From: Alex Budd [REDACTED]
Sent: 16 December 2021 16:09
To: [REDACTED]
Subject: Burndell Road, Yapton (F/22/21/PL) - Additional Information Request
Attachments: 2020-6145-002 Rev I.pdf; 2020-6145-001 Rev J.pdf; 2020-6145-000 Rev -.pdf

I write to you reference the development proposal at Burndell Road, Yapton planning reference F/22/21/PL.

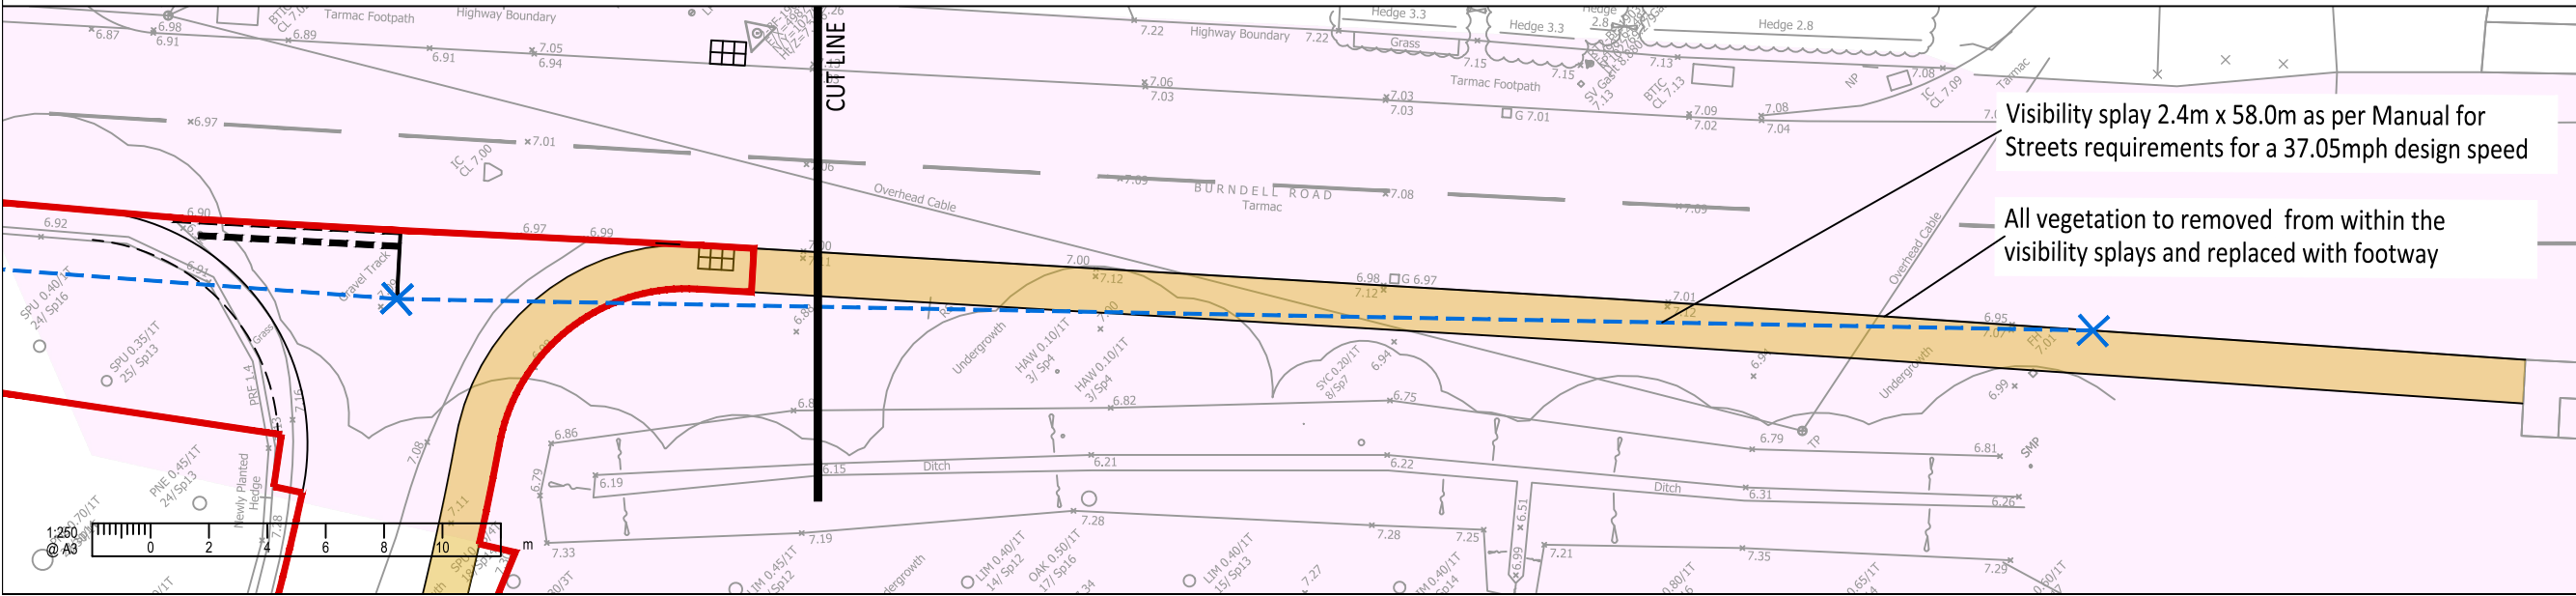
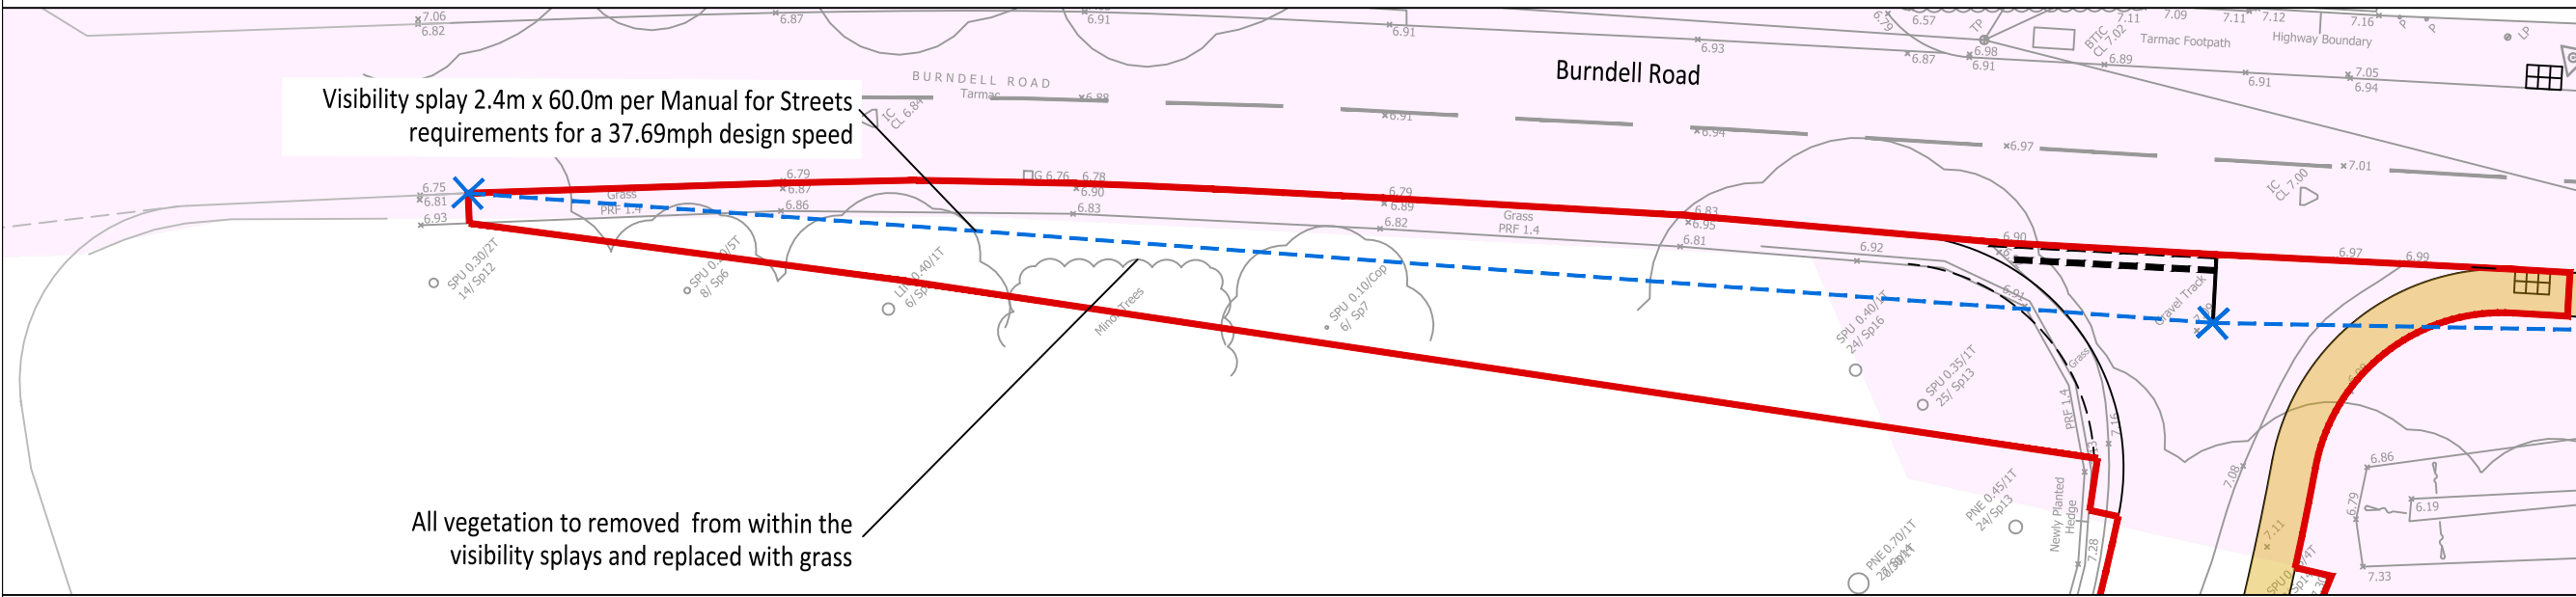
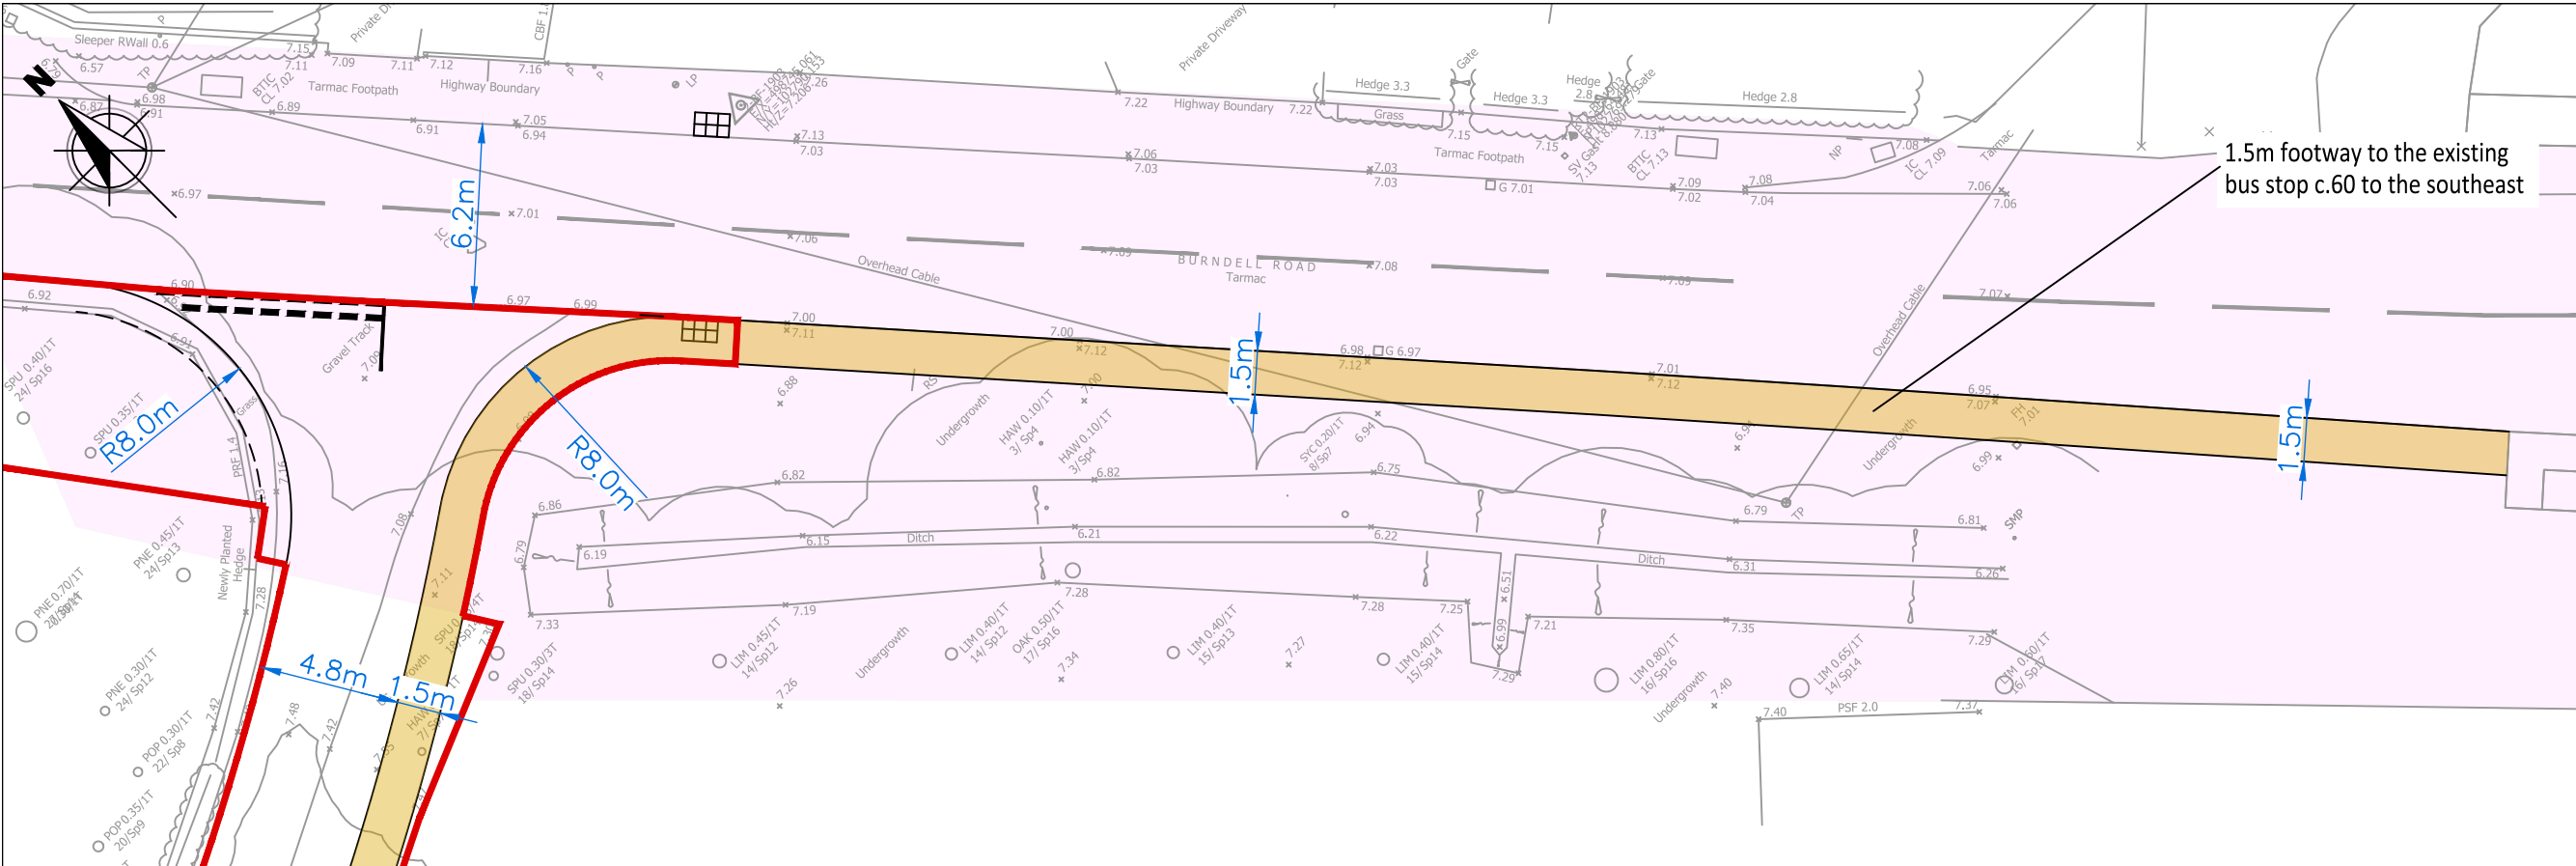
1. WSCC requirement: *'Show splays of 2.4m by 58m south and 60m north can be accommodated without passing through third party land'.*

Please find attached a revised access Drawing 2020-6145-001(rev. J), which shows the site ownership boundary marked in red and the reduced visibility splays of 2.4m x 58m looking south and 2.4m x 60m looking north.

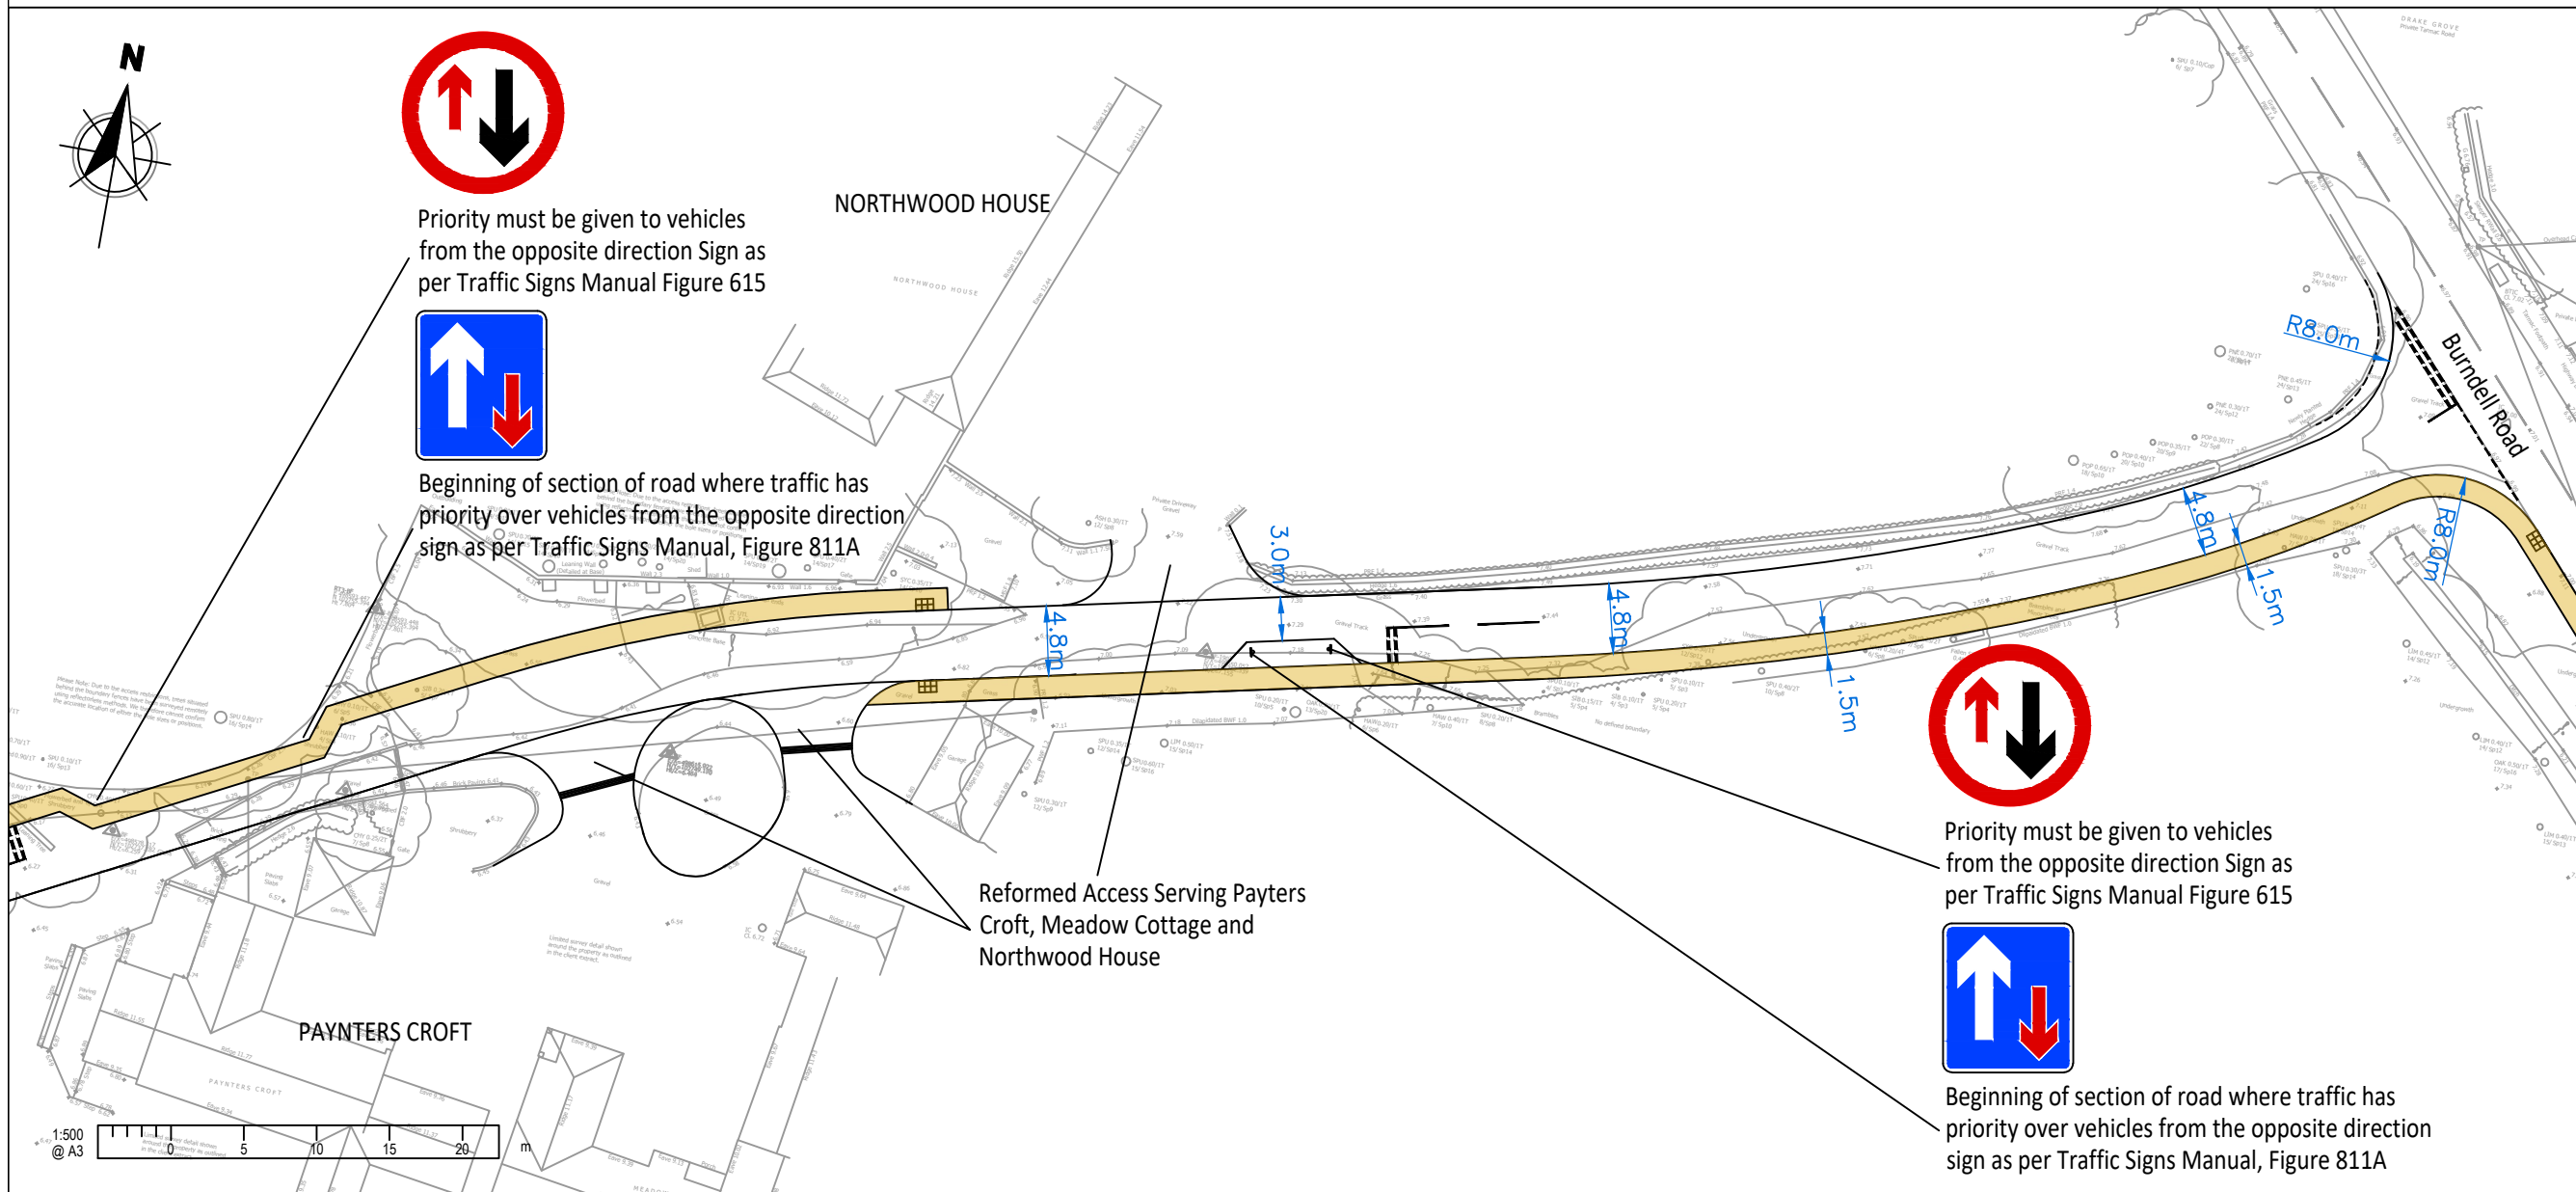
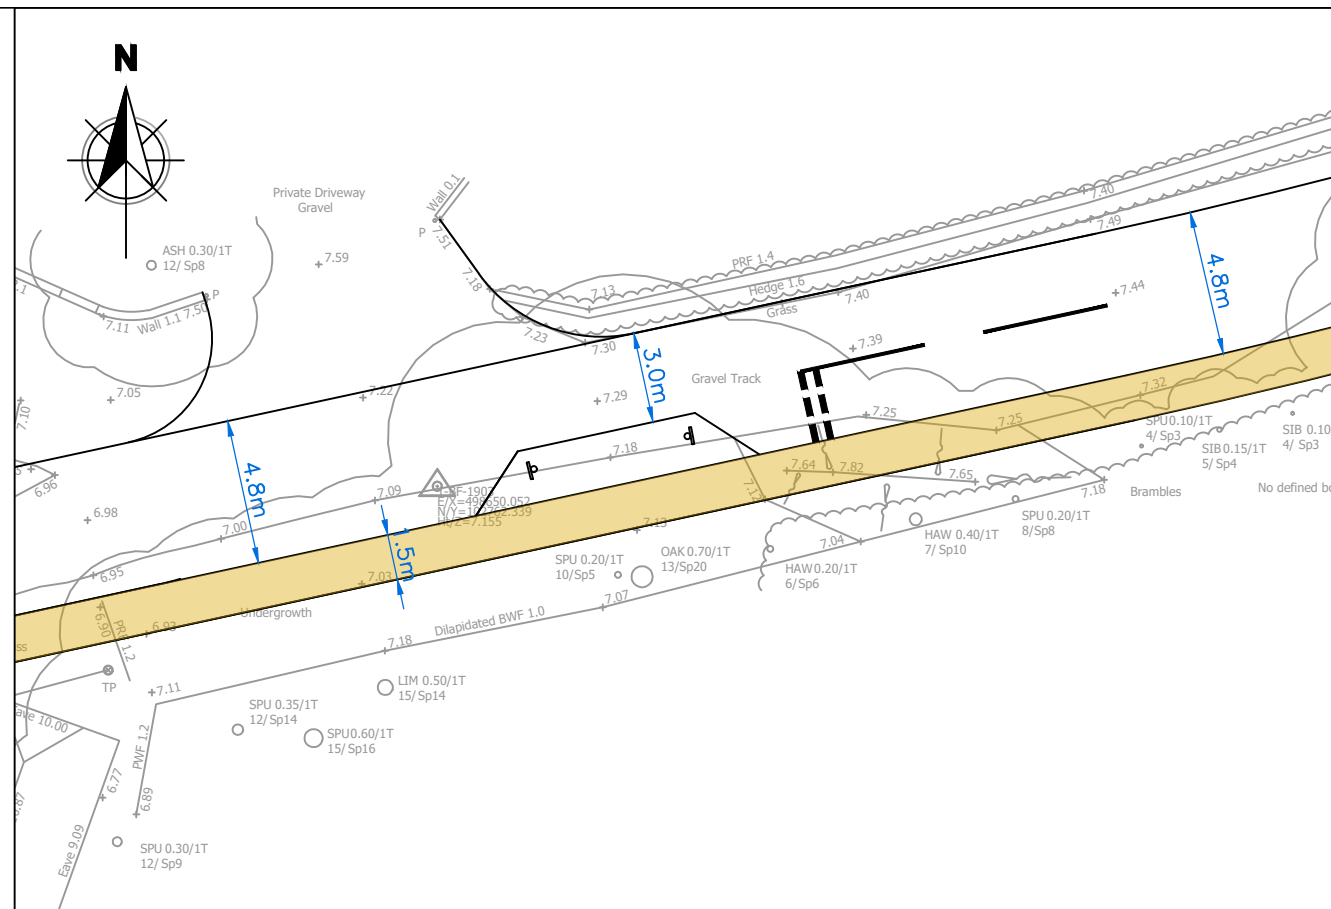
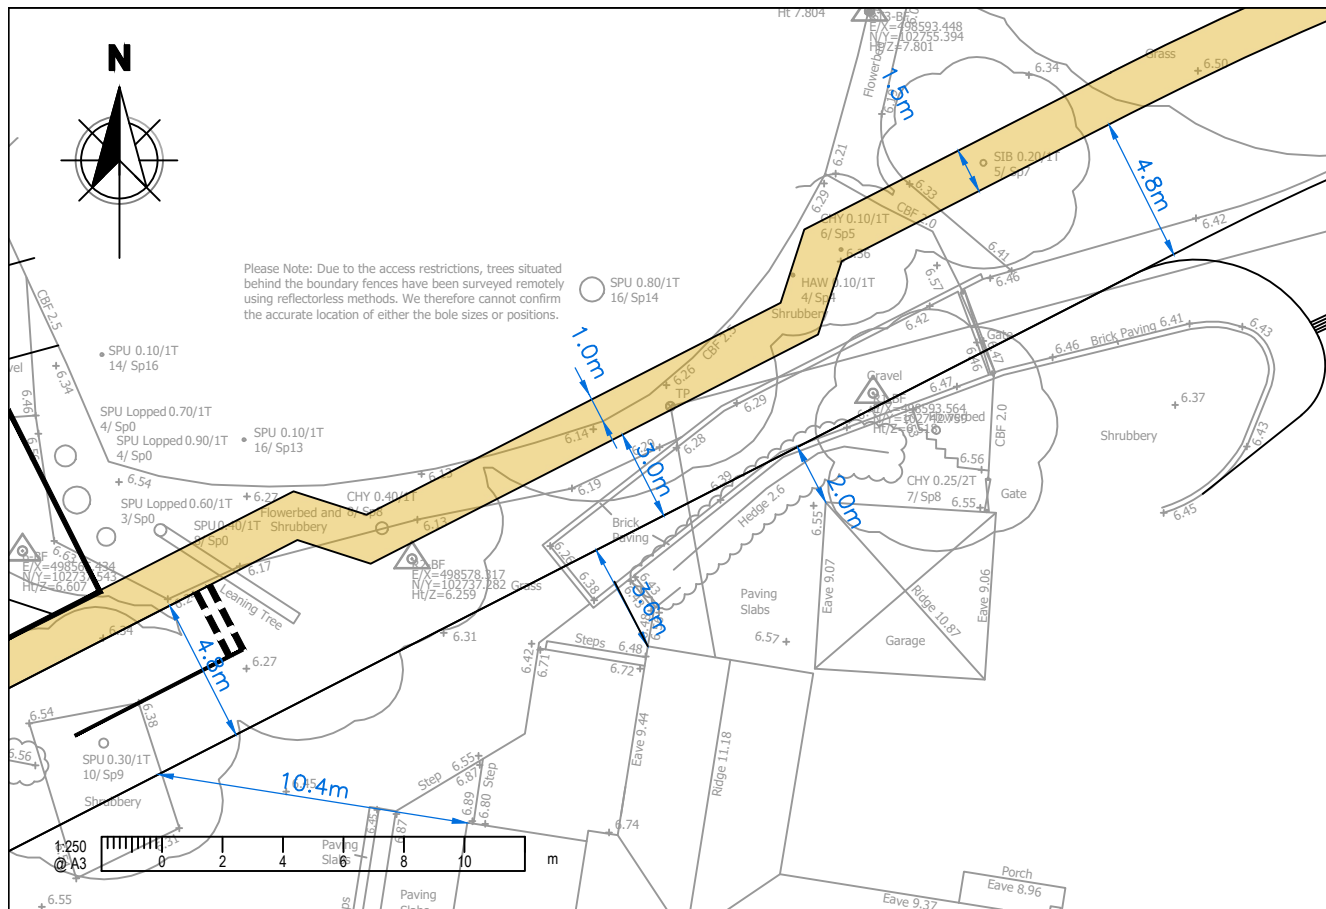
2. WSCC requirement: *'Clearly show extent of footway from access road past plots 1 and 2'.*

The discrepancy between the architectural drawings and highways drawings is noted. The correct footway arrangement is shown in Drawing 2020-6145-002 (Rev. I) attached. The architects' drawings will be updated to reflect this.
